**OUFC Planning Application Ref: 24/00539/F**

## **Proposed Transport Strategy**

### **From: Friends of Stratfield Brake (FoSB)**

**This is an objection to the applicant's proposed transport strategy. Transport is a key area of concern for us.**

TITLE:  
**GENERAL ARRANGEMENT  
PART 3 OF 4**

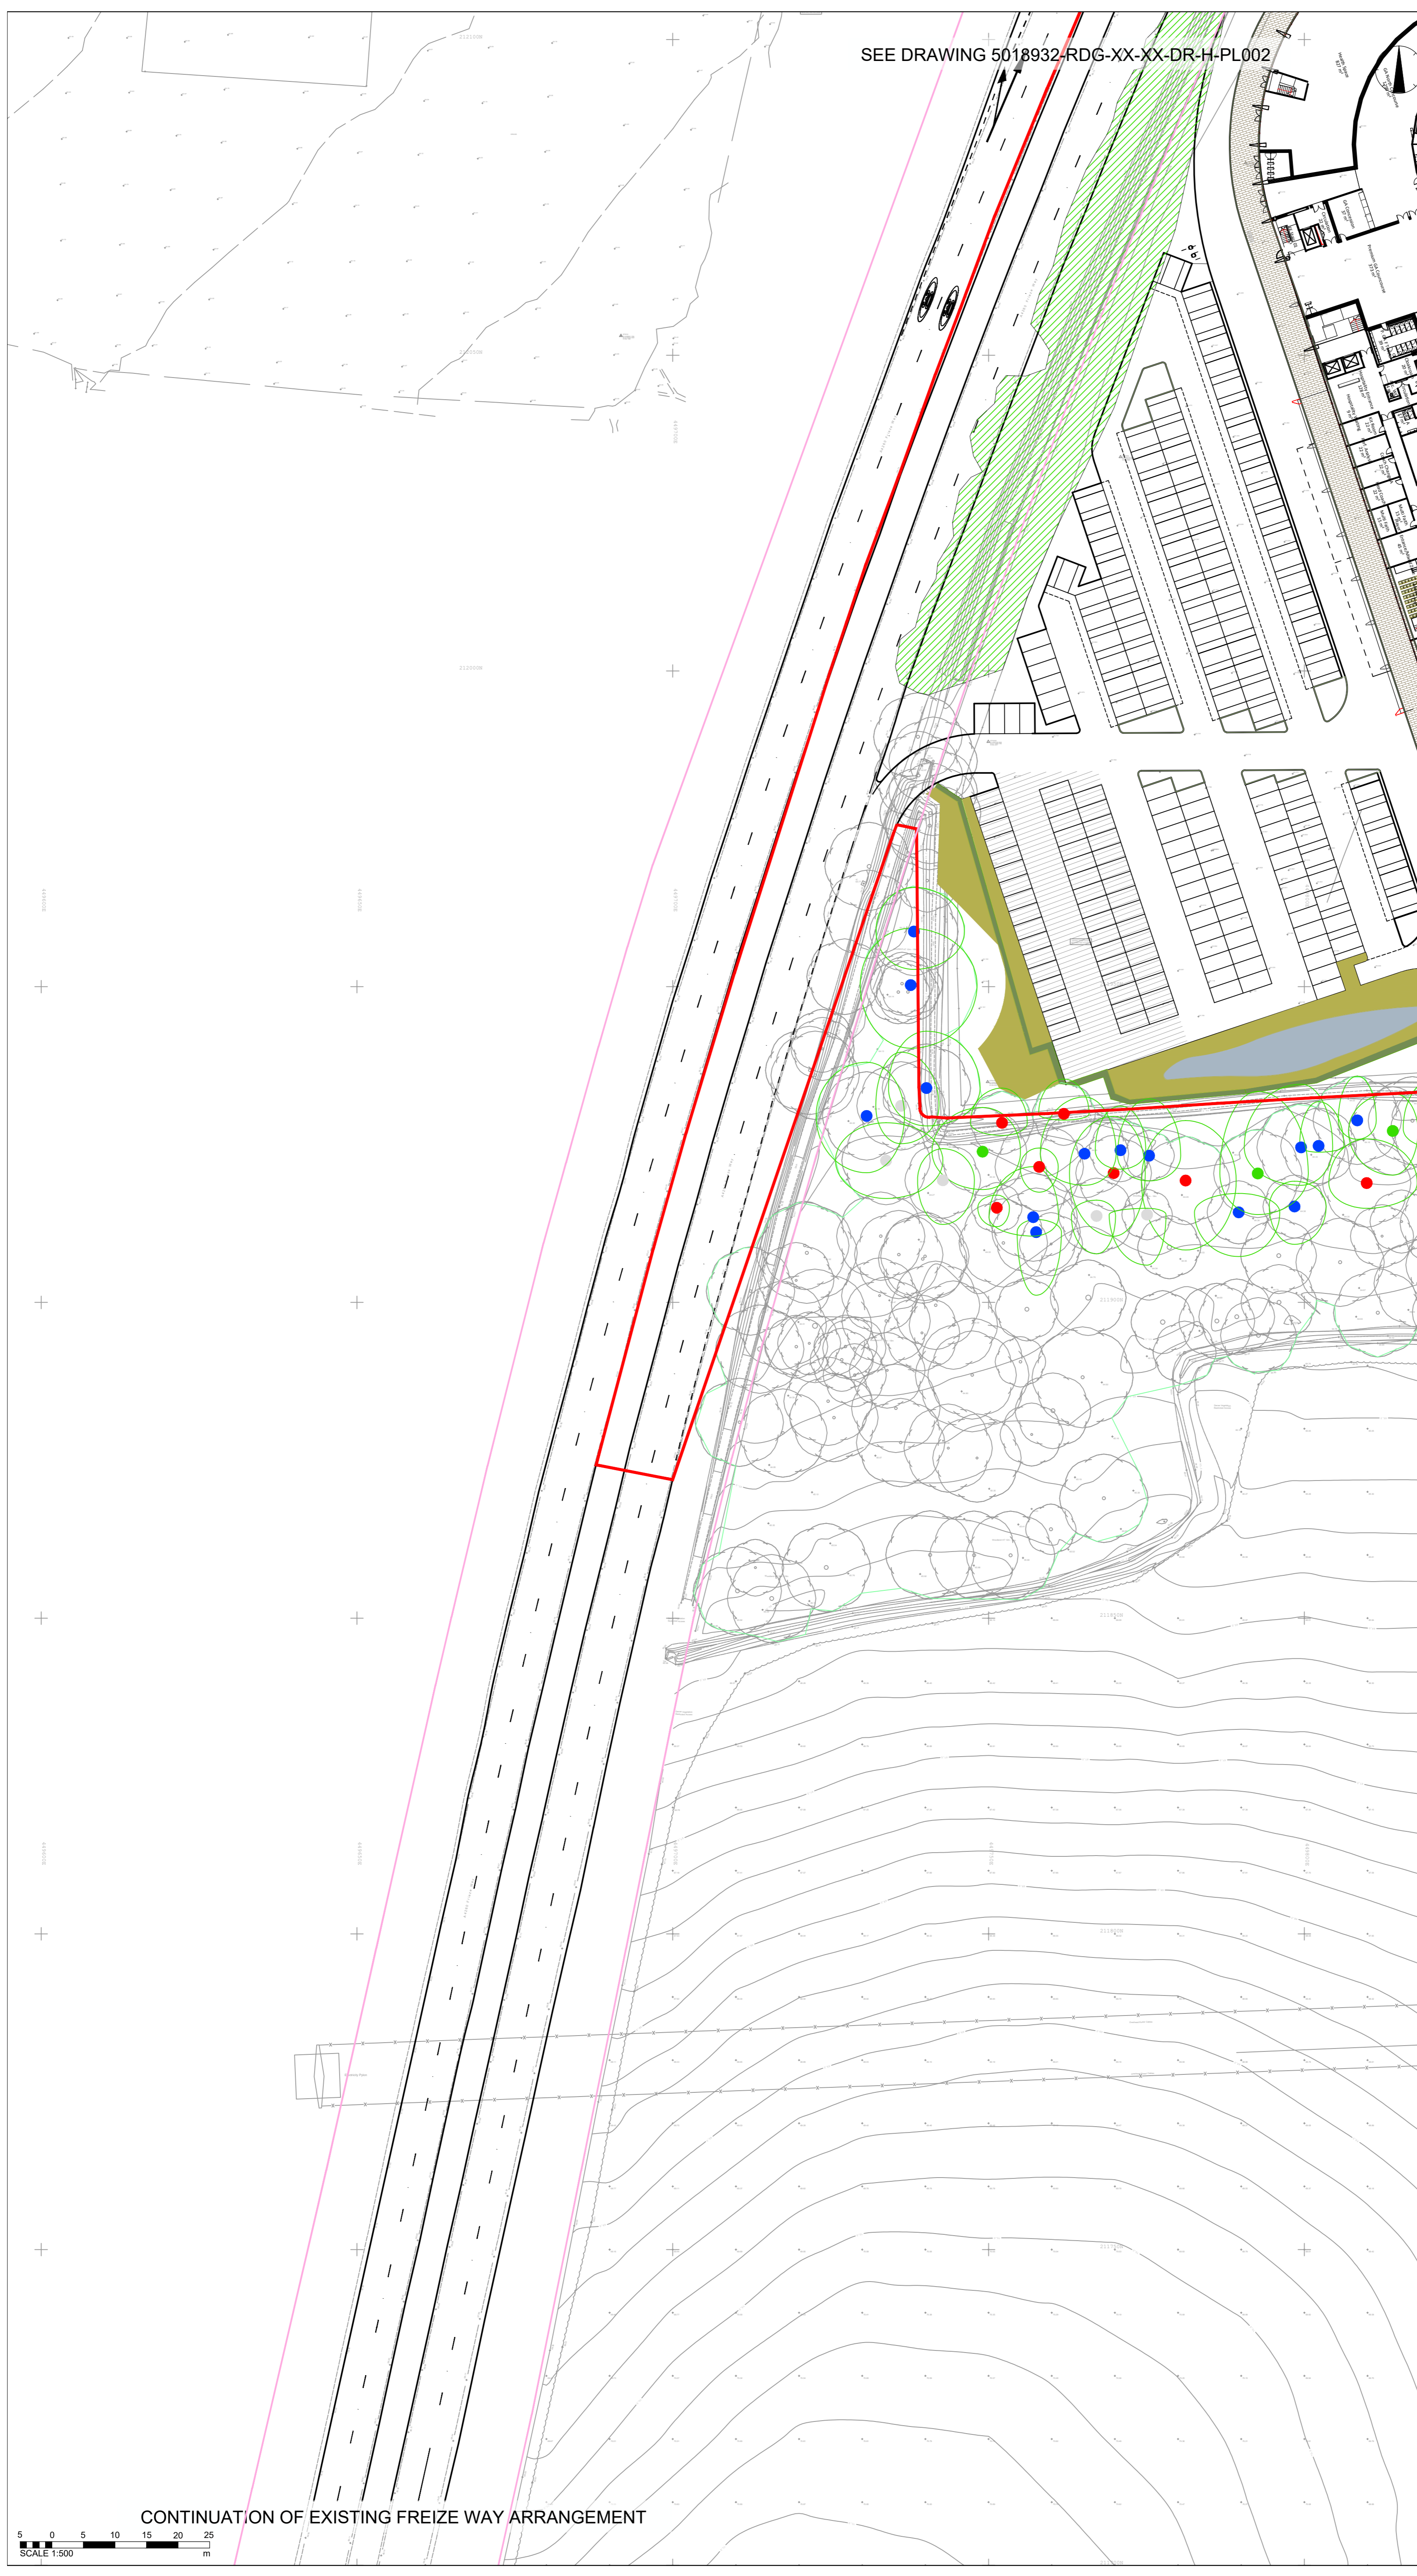
- The bus lane southbound from the Kidlington Roundabout to Oxford Parkway has been removed in the stadium plans. This is another anti-bus measure that will lead to delays for buses and therefore passengers. People who use public transport to commute using this route should not be disadvantaged by the removal of a bus lane.

- The 3m pathway plus .5m buffer zone on Frieze Way (as required by OCC) would appear to mean further loss of vegetation and biodiversity and will affect the BNG metric.
